**KIRKLEES METROPOLITAN COUNCIL
INVESTMENT & REGENERATION SERVICE**

DELEGATED DECISION TO DETERMINE PLANNING APPLICATIONS

Reference No:	2026/62/90631/E
Site Address:	774, Bradford Road, Birstal, Batley, WF17 8NL
Description:	Erection of two storey and first floor extension to create dwelling forming annex accommodation associated with 774, Bradford Road, Birstal, Batley, WF17 8NL
Recommending Officer:	Jennifer Booth

DECISION - REFUSED

Notes :-

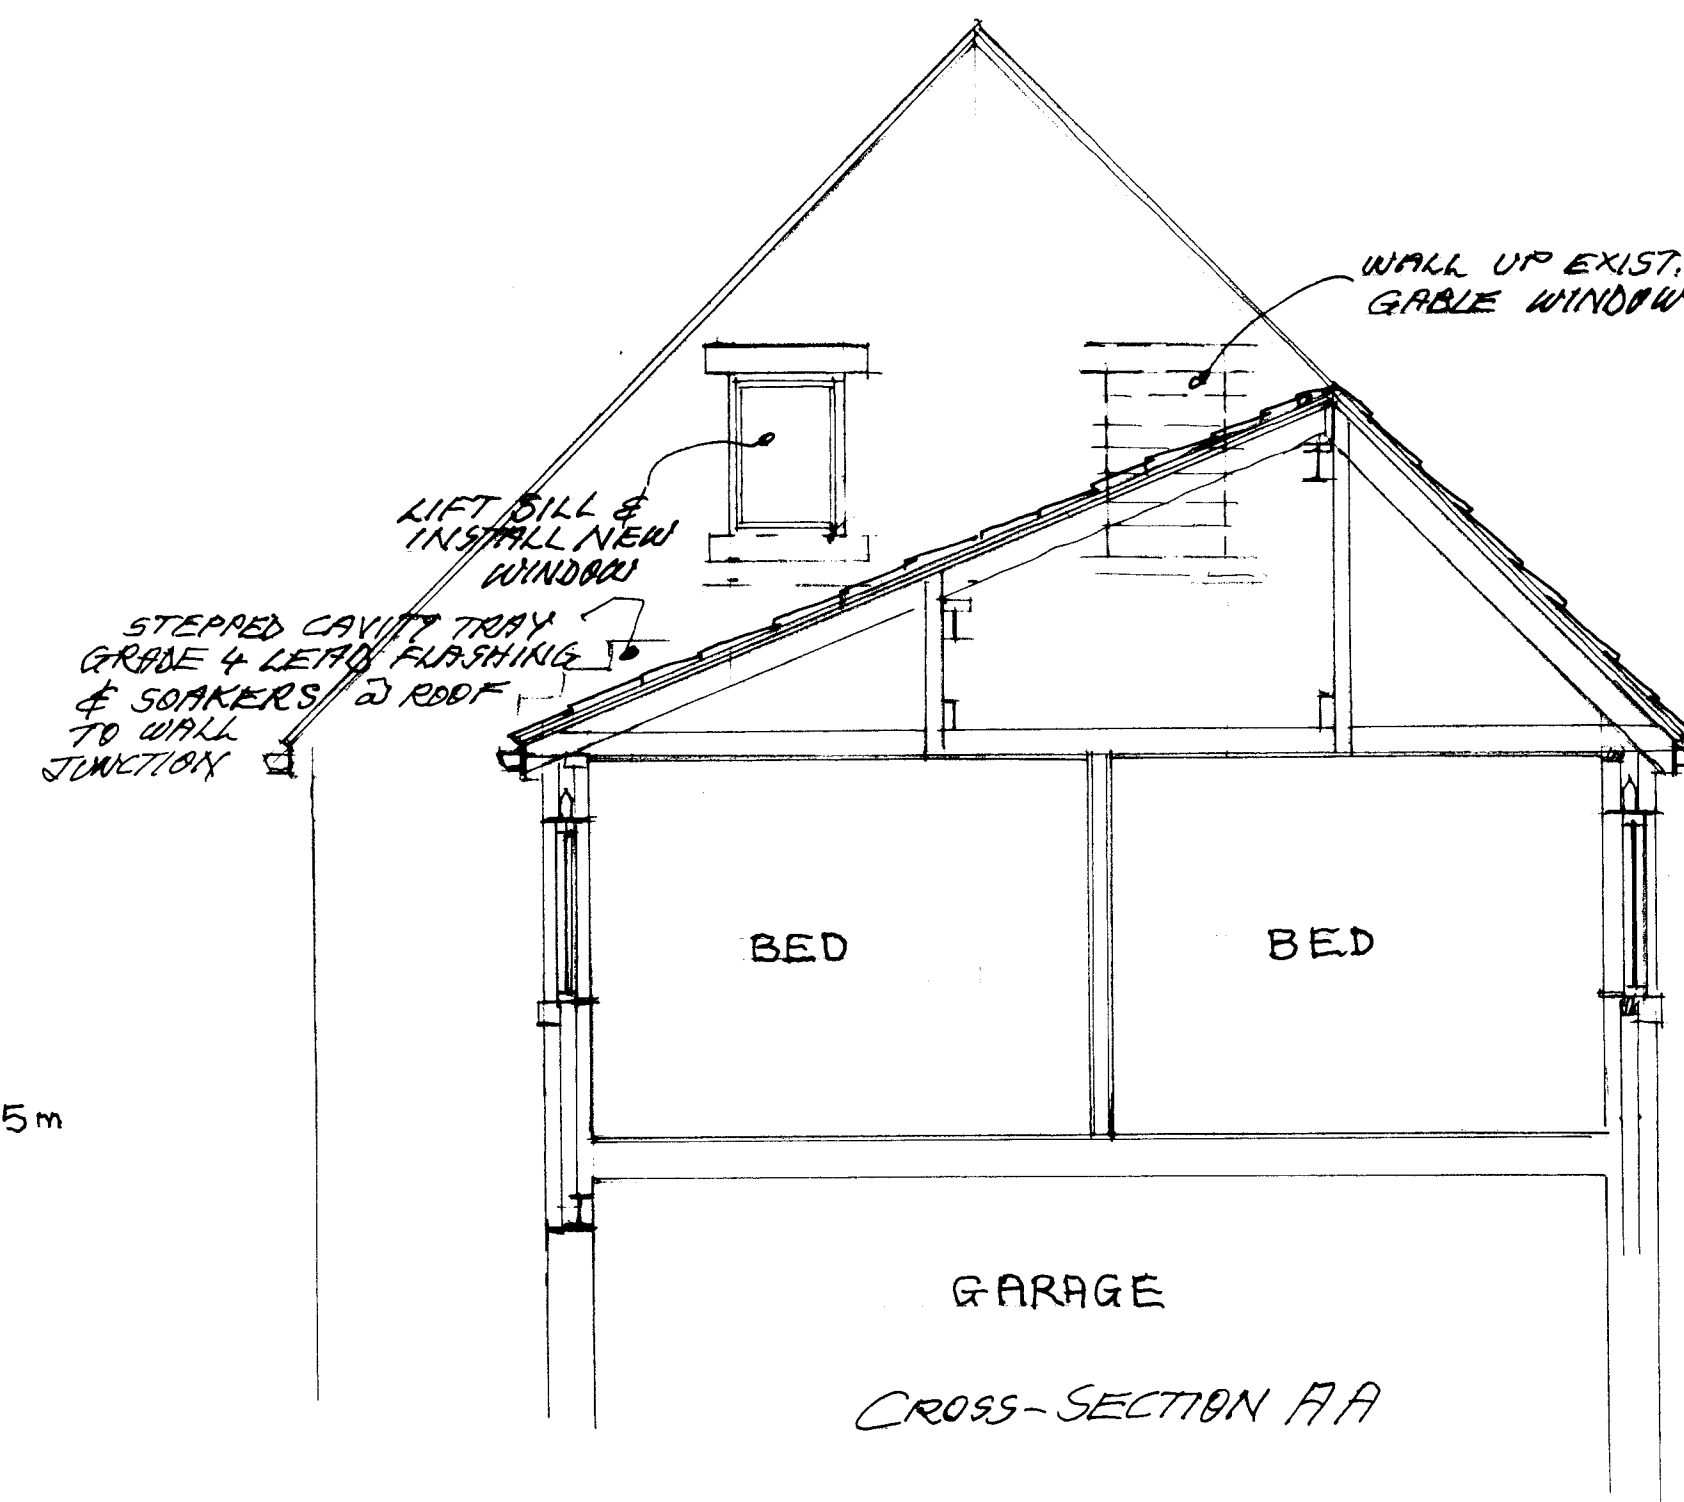
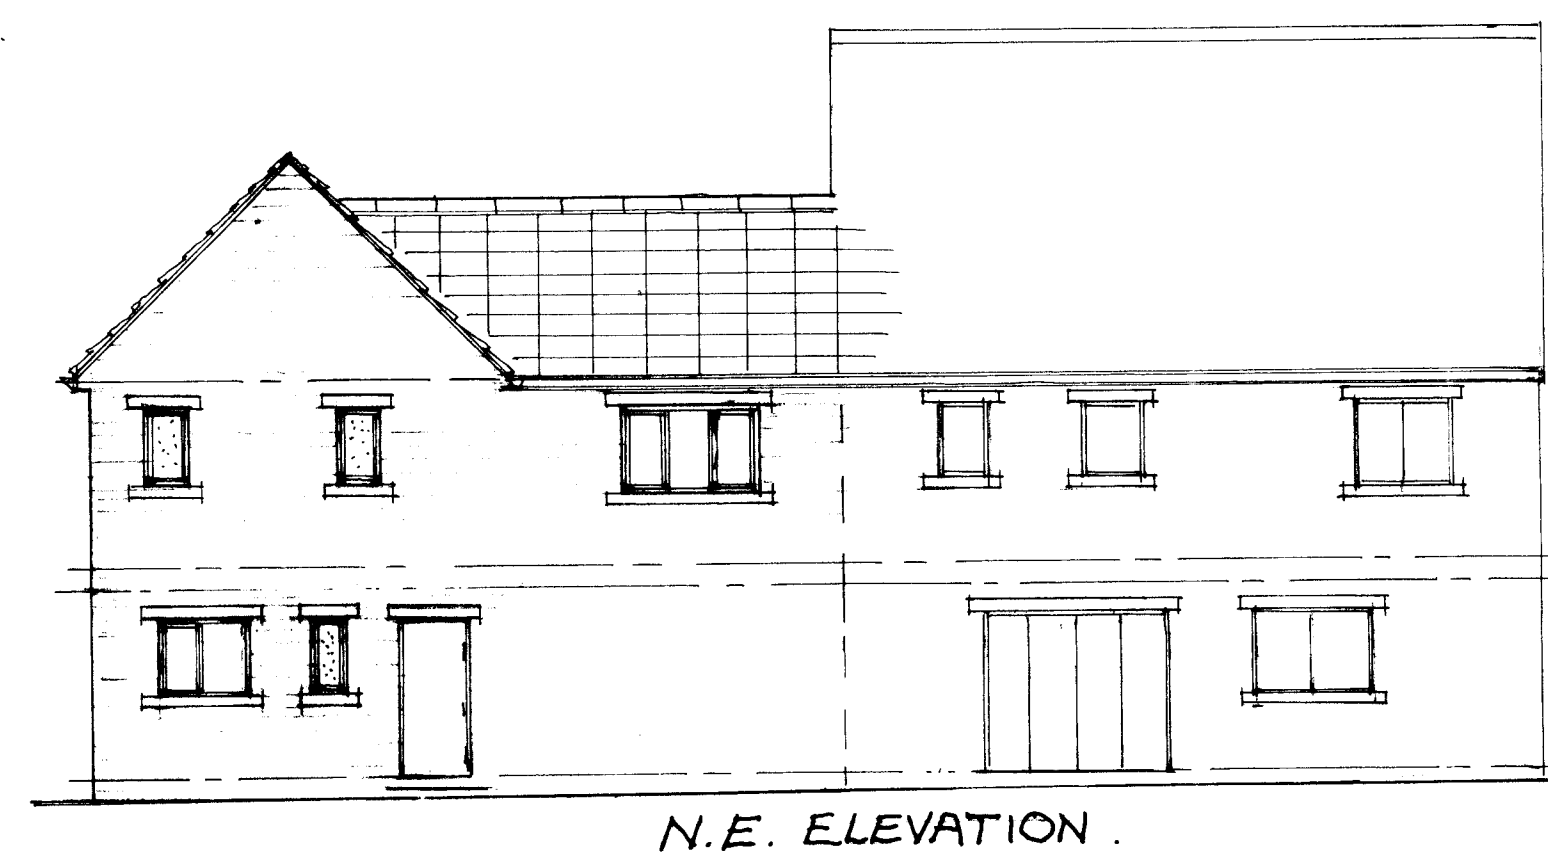
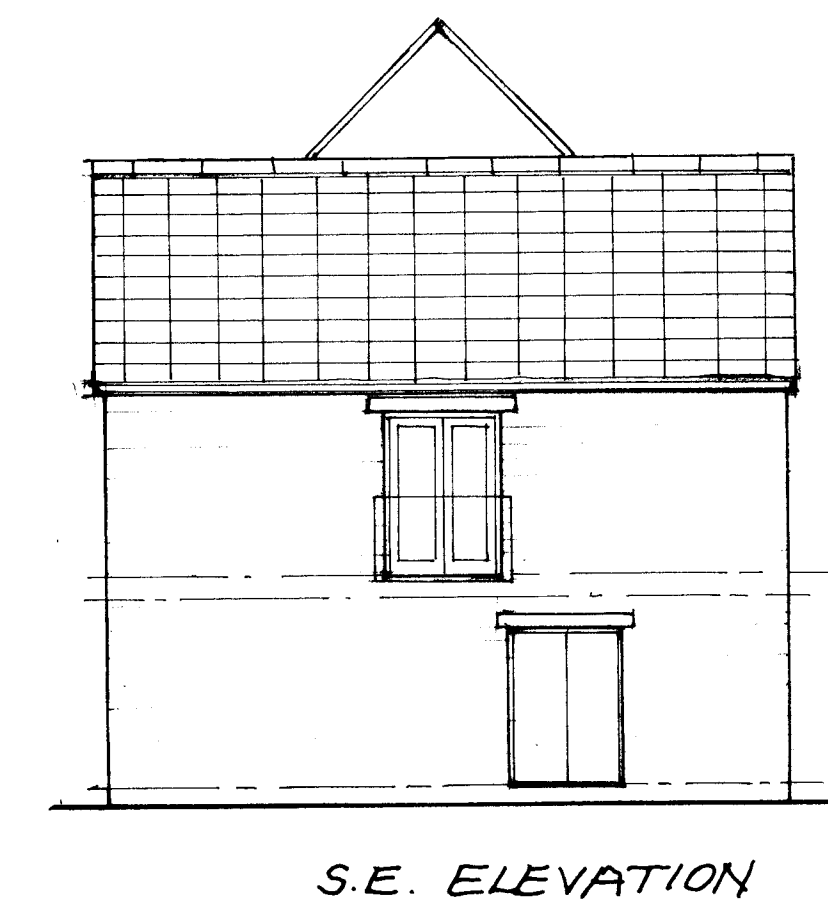
The plans show a living room, kitchen and wc on the ground floor of the extension adjoining the existing garage with a first floor over both the garage and the new ground floor accommodation with three bedrooms, one with an ensuite and a family bathroom.

The first floor extension over the garage and to the side would have an upper projection of 10m with the additional ground floor projecting 5.3m. The roof form would be a sloping pitch.

The annex is considered to be significantly larger than would be considered appropriate and acceptable and does not appear subordinate to the main dwelling thereby appearing as a separate dwelling unit.

In addition, it does not rely on any internal features of the main house, although it is acknowledged that external amenity space would be shared. Furthermore, the design of the annex is not considered to be complimentary to the style and character of the main property. Amended plans have not been requested.

The proposed annex is considered to be significantly larger than would reasonably be acceptable for such an addition and, as a result, fails to appear subordinate to the host dwelling contrary to the House Extensions & Alterations SPD. Its scale and independent nature are further emphasised by the lack of reliance on shared internal facilities within the main house,

functioning instead as a largely self-contained unit, notwithstanding the acknowledgement that external amenity space would be shared.

Furthermore, the design approach adopted for the annex is not considered to be sympathetic or complementary to the architectural style and character of the main dwelling, resulting in a form of development that appears incongruous within its context and harmful to the overall visual coherence of the site.

The proposed annex has been assessed against the Nationally Described Space Standards (NDSS). In order to meet the standards the accommodation for a three bedroom, 6 person unit should provide 102sqm. Measuring the annex it would exceed this standard at 111sqm. As the accommodation is ancillary, weight is afforded to this due to the flexible living provided in association with the main dwellinghouse with access to outdoor space. The bedrooms provide between 24.2sqm and 12.8sqm of space which is in compliance with the NDSS. These dimensions ensure an acceptable standard of internal amenity for future occupants, with adequate space for day-to-day living and circulation. There is also access to the shared amenity space with the main dwelling.

In terms of the impact on the amenity of the occupants of the host dwelling, it is noted that the annex would be adjoining the side elevation of the main house. The proposal would not significantly increase, loss of light, or other amenity impacts for the occupants of the main dwelling per se but would reduce the amenity space appearing overdeveloped.

The proposed annex, by virtue of its scale and massing, fails to appear as a subservient addition to the host dwelling and instead represents a form of development that is disproportionately large. Notwithstanding the sharing of external amenity space, the annex lacks ancillary connection to the main dwelling rather than dependent accommodation, undermining the ancillary form of accommodation. Furthermore, the design of the annex is not considered to be sympathetic or complementary to the architectural style and character of the main dwelling, resulting in an incongruous form of development that is detrimental to the character and appearance of the site and surrounding area. To permit the proposals would be contrary LP24 of the Kirklees Local Plan, KDP1 & KDP2 of the House Extensions & Alterations SPD and Chapter 12 of the National Planning Policy Framework.
